Our ref
A/44/26/PL

Proposal: Retention of 40 No dwellings (after demolition of previous buildings) and associated operations

Site address: Former Shrublands Nursery Roundstone Nursery Angmering BN13 4AT

PL- Consultation- Southern Water response

DRAINAGE (SHEET 1)

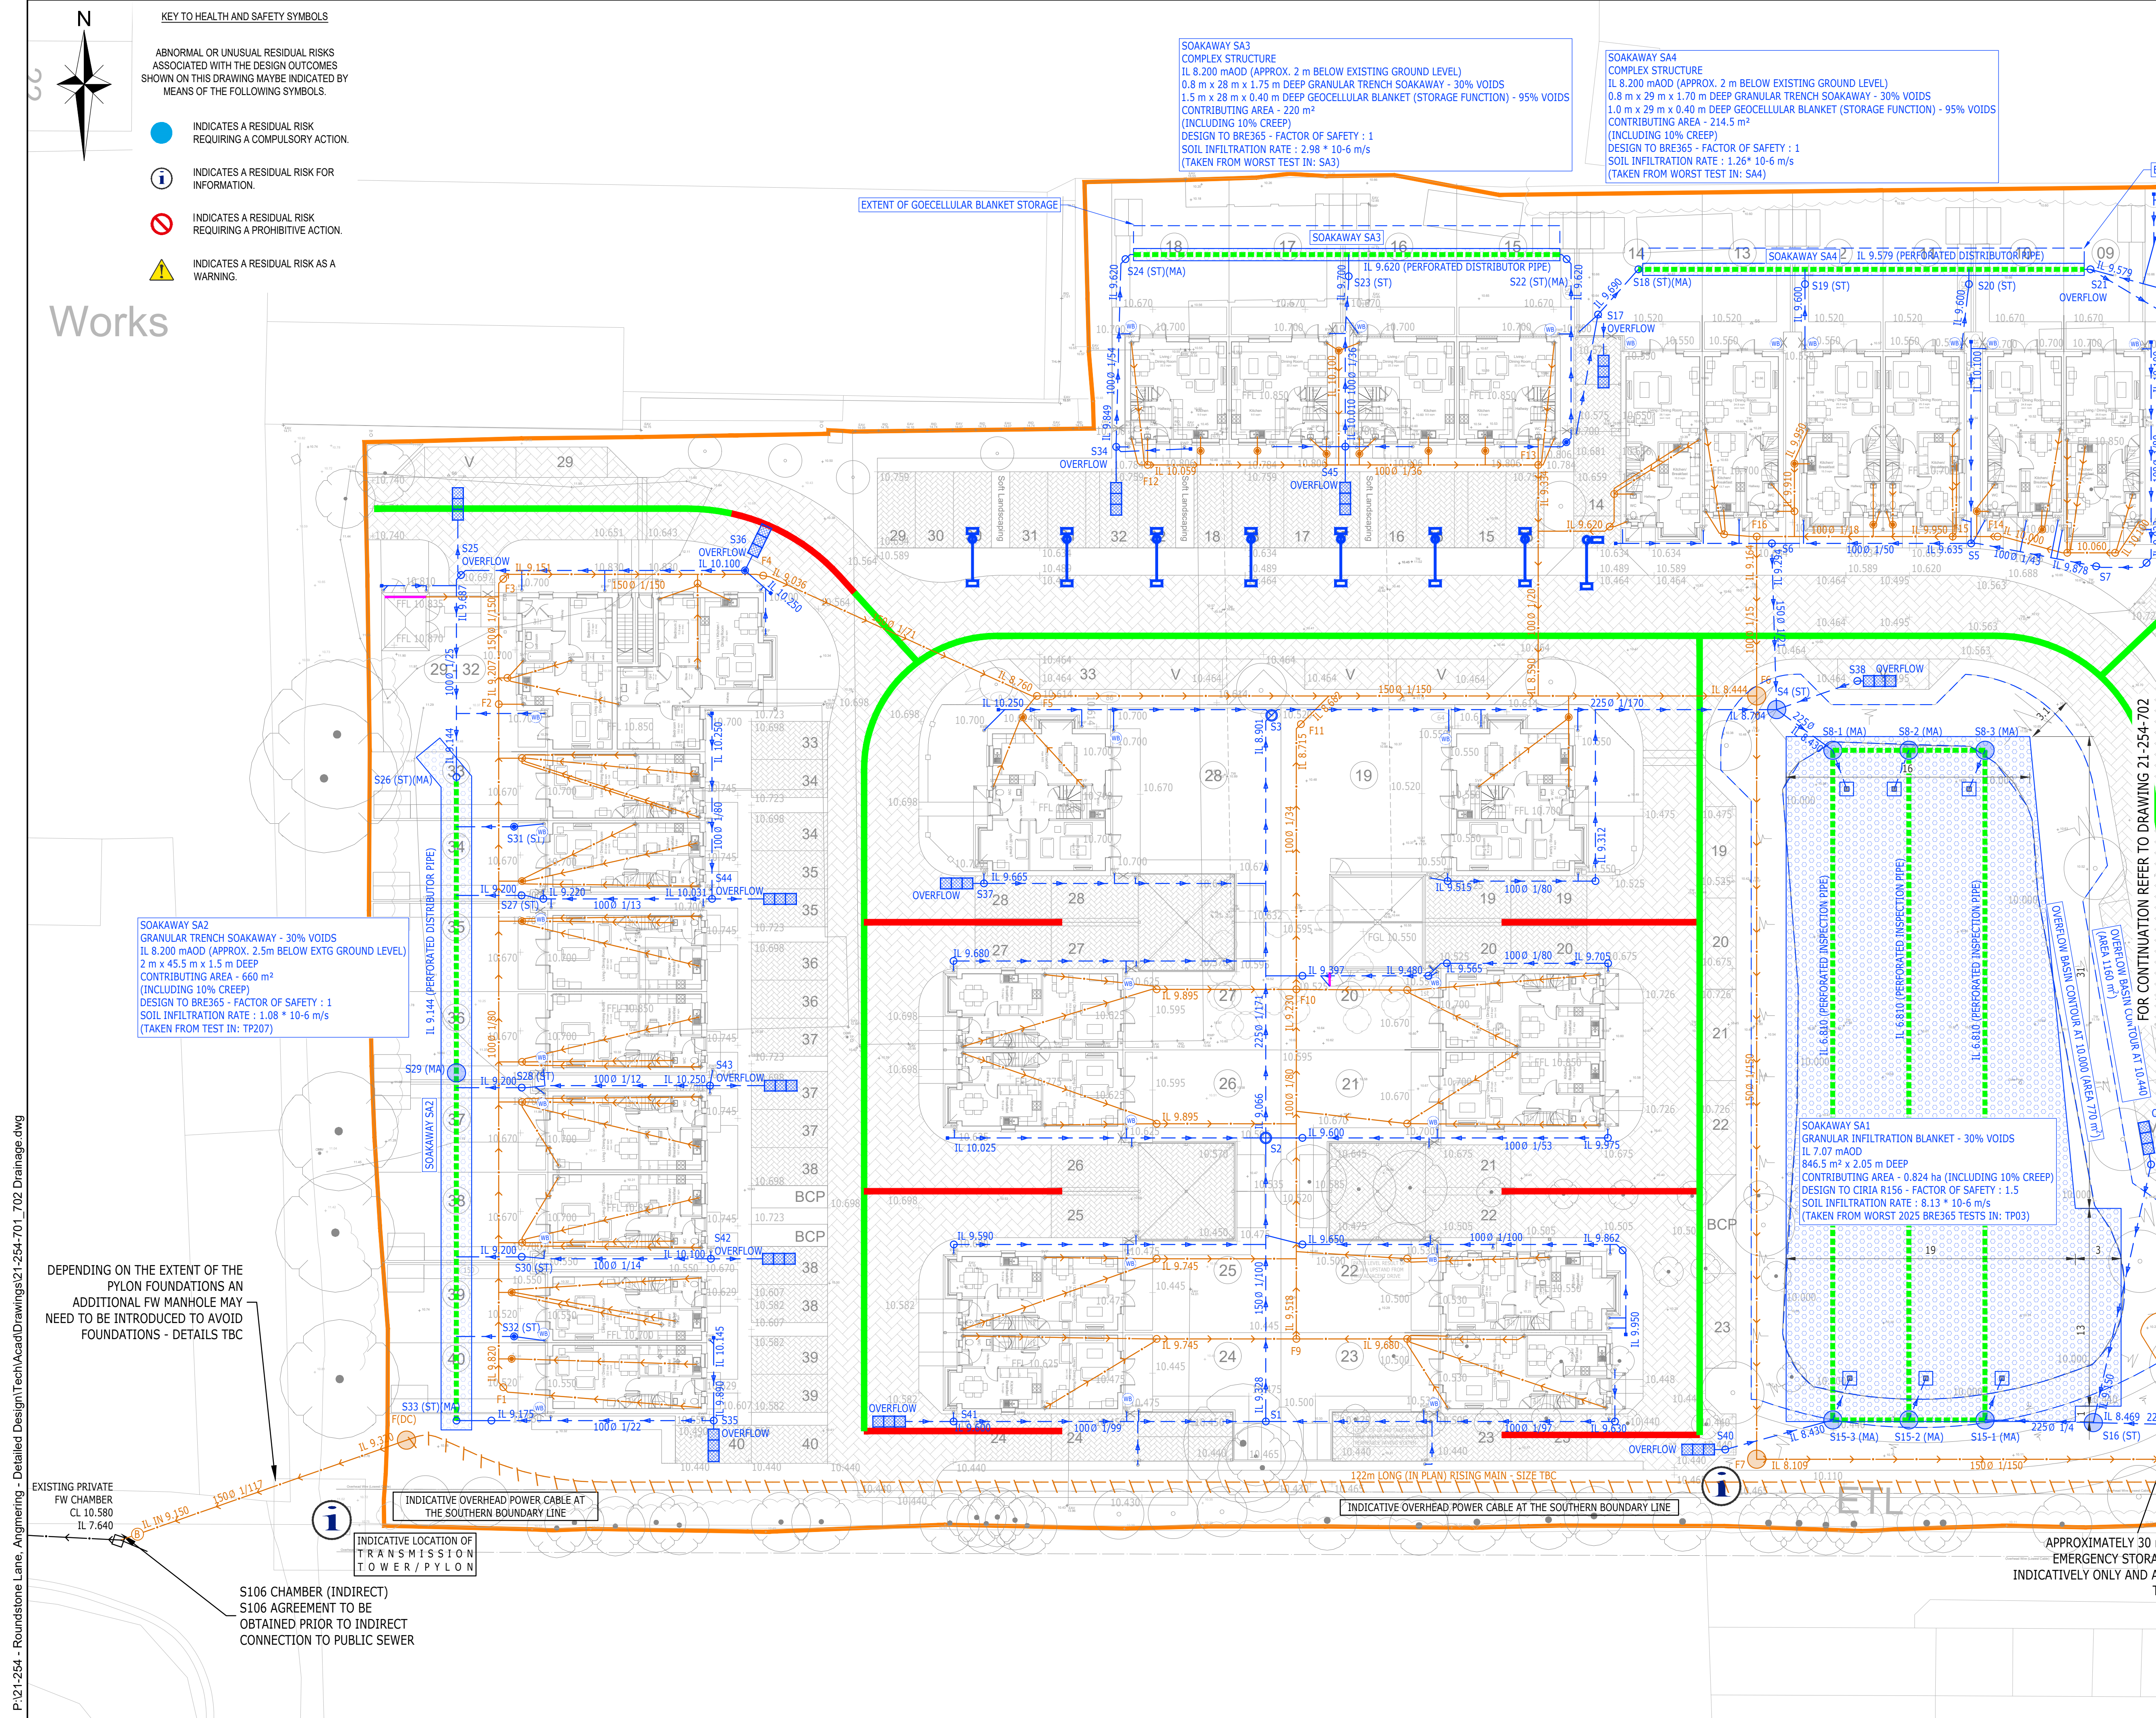
The plan provided by the developer drawing no 21-254-703 shows a sewer crossing the site which is not shown on our records. An assessment of the sewer is required to determine its ownership and the impact it could have to the proposed site layout. It is possible that the sewer is now deemed to be public. To get in contact to confirm the exact position of the asset please visit; https://www.southernwater.co.uk/media/ph4fk3pe/ds-location-of-rising-mains_pb.pdf. For information on required stand off distances from public sewers please refer to: <https://www.southernwater.co.uk/media/st5orjvm/stand-off-distances.pdf>
